05.09. 2024

Representation for planning application 2024/70/92167, Jones Homes (Yorkshire) Ltd, Land off, Edgerton Road, Edgerton, Huddersfield, HD3 3AA:

Deveron Grove
Proposed Site Layout

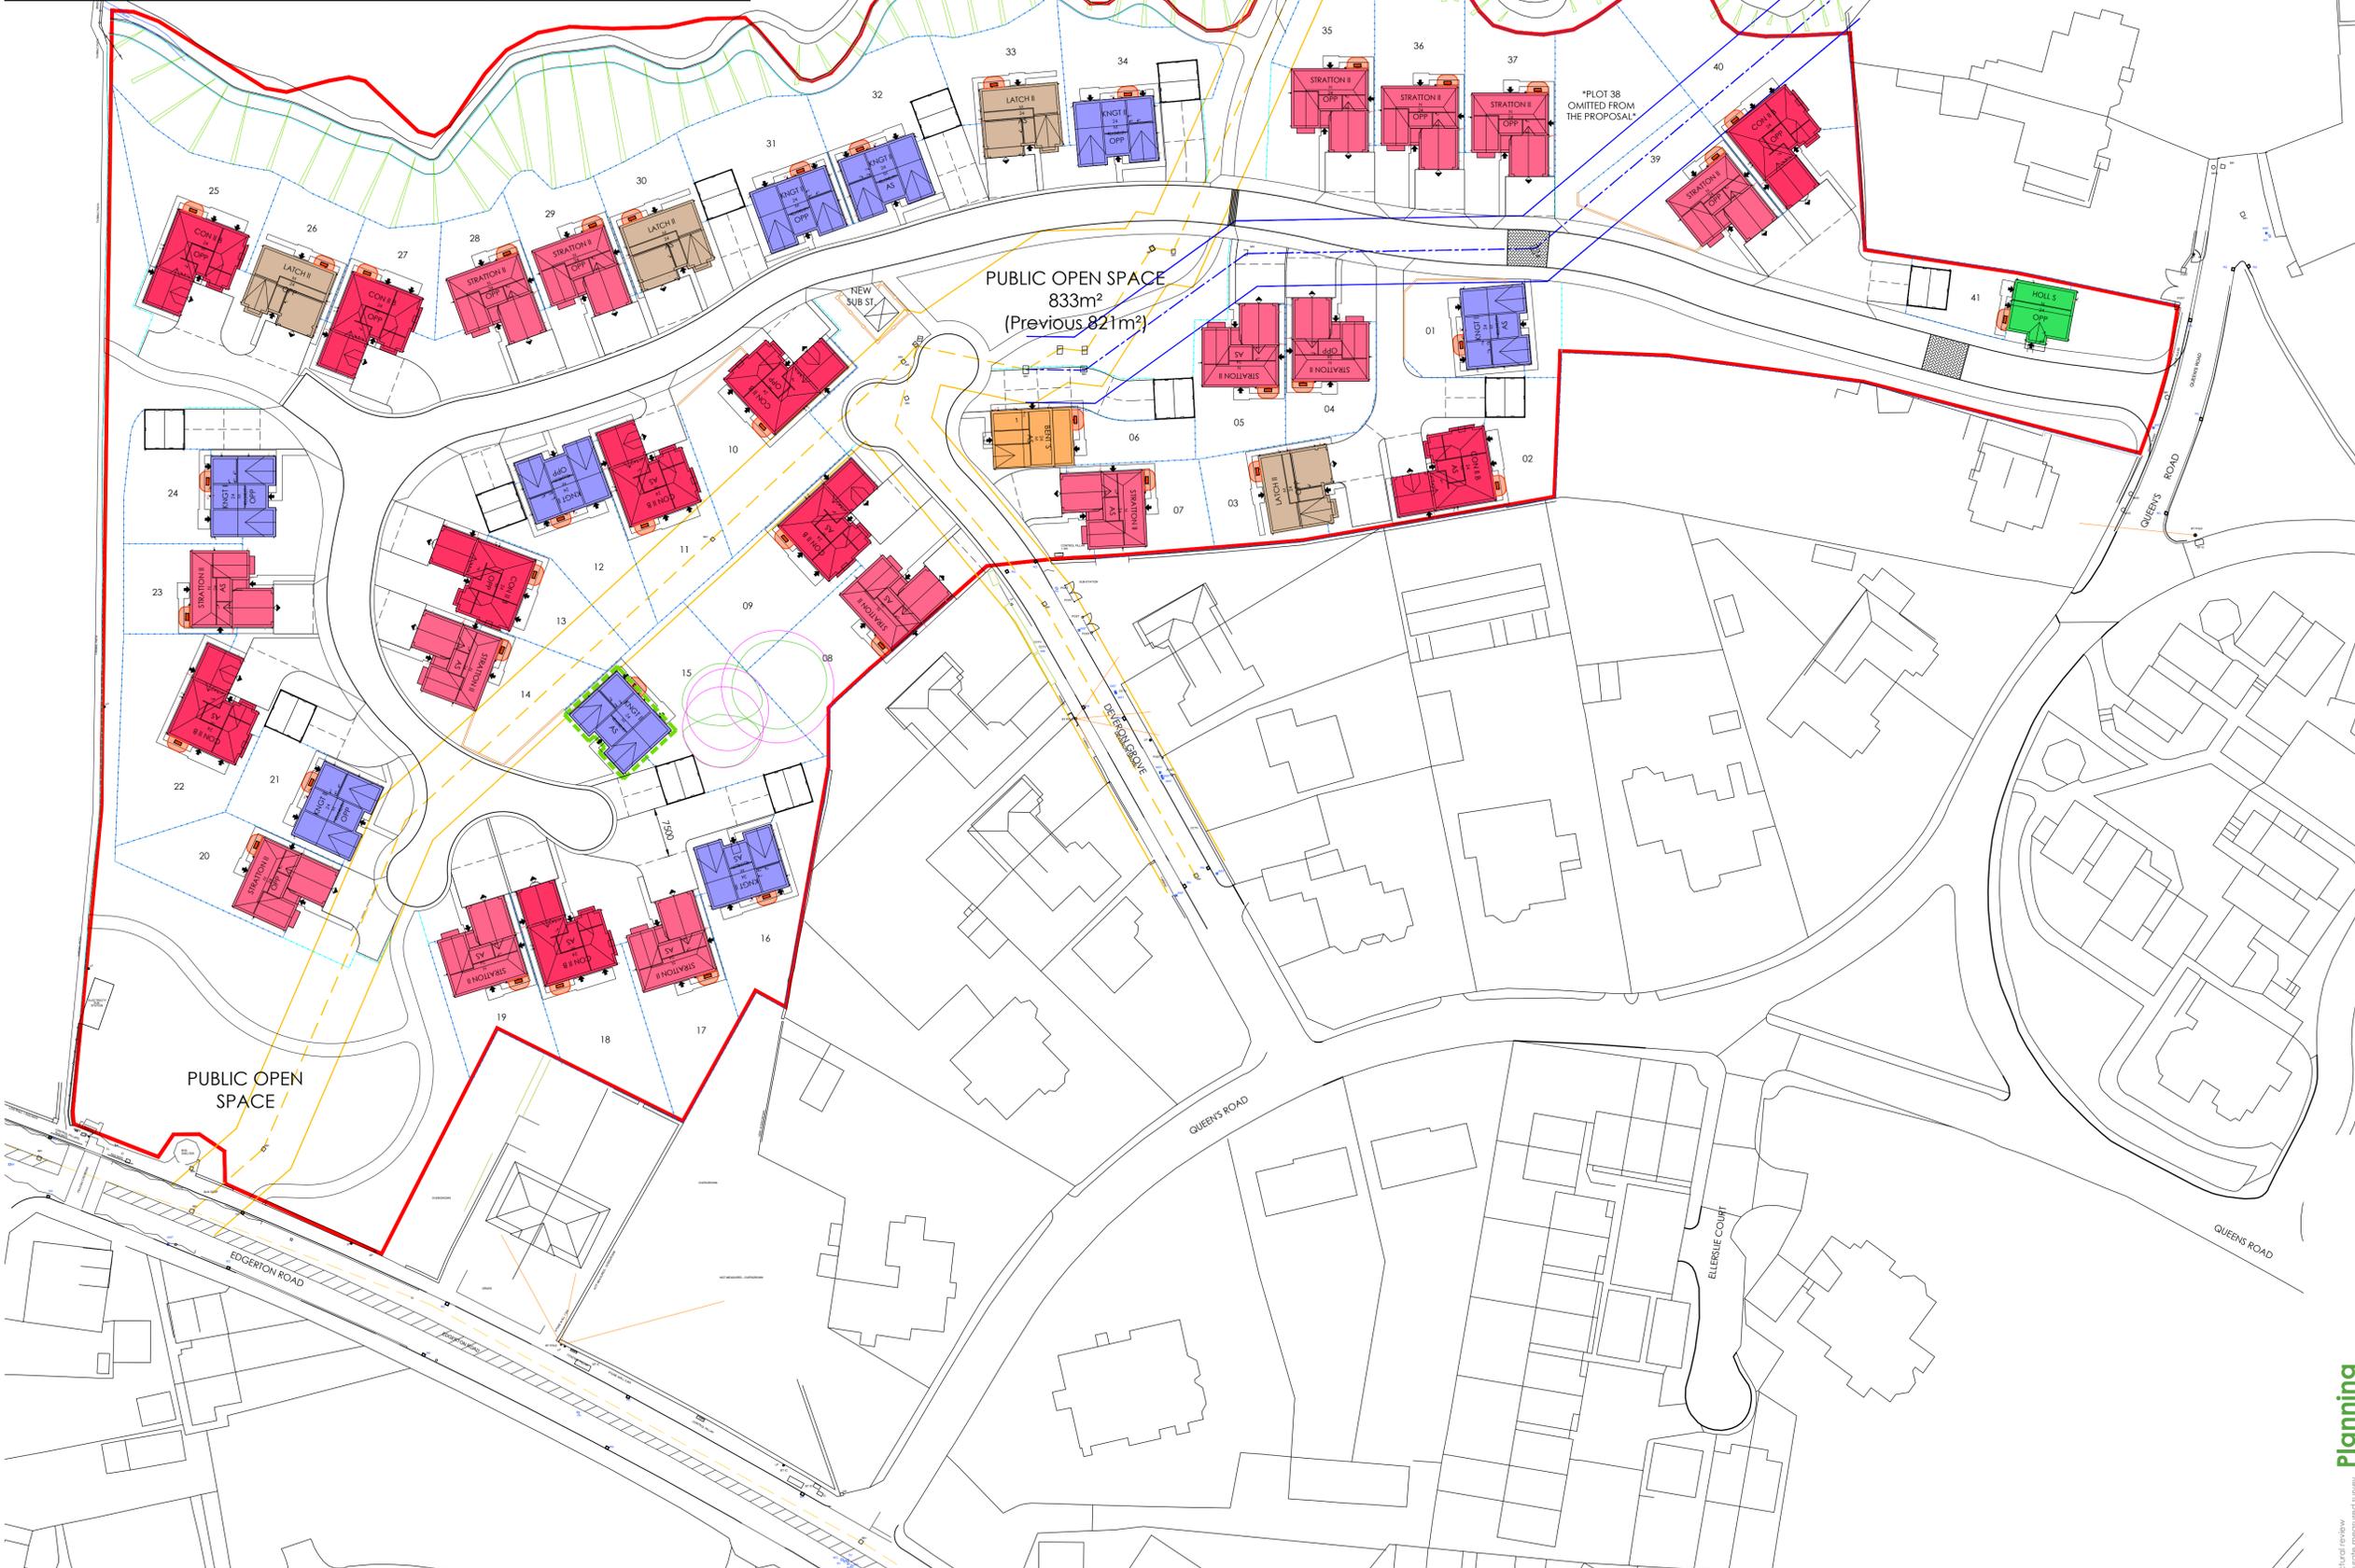
1. The plans submitted by Jones Homes show the land ownership of “Land off, Edgerton Road, Edgerton, Huddersfield, Huddersfield, HD3 3AA” (Clayton Fields), extending beyond Clayton Dike onto Clayton Fields Allotments. **The land ownership of the development site (Clayton Fields) never crosses Clayton Dike. The correct land ownership should be shown on the submitted plans before planning permission is renewed.**

2. The submitted plans do not show the existing public rights of way footpaths (which are cited in the planning notice). The plans should be corrected to show the locations of both the present (cited) rights of way footpaths and their relocation as part of any future development (once the rights of way planning condition has been satisfied).

3. Improvement of the existing storm sewage system under the development site, particularly the run off into Clayton Dike, should be improved as part of any future development.
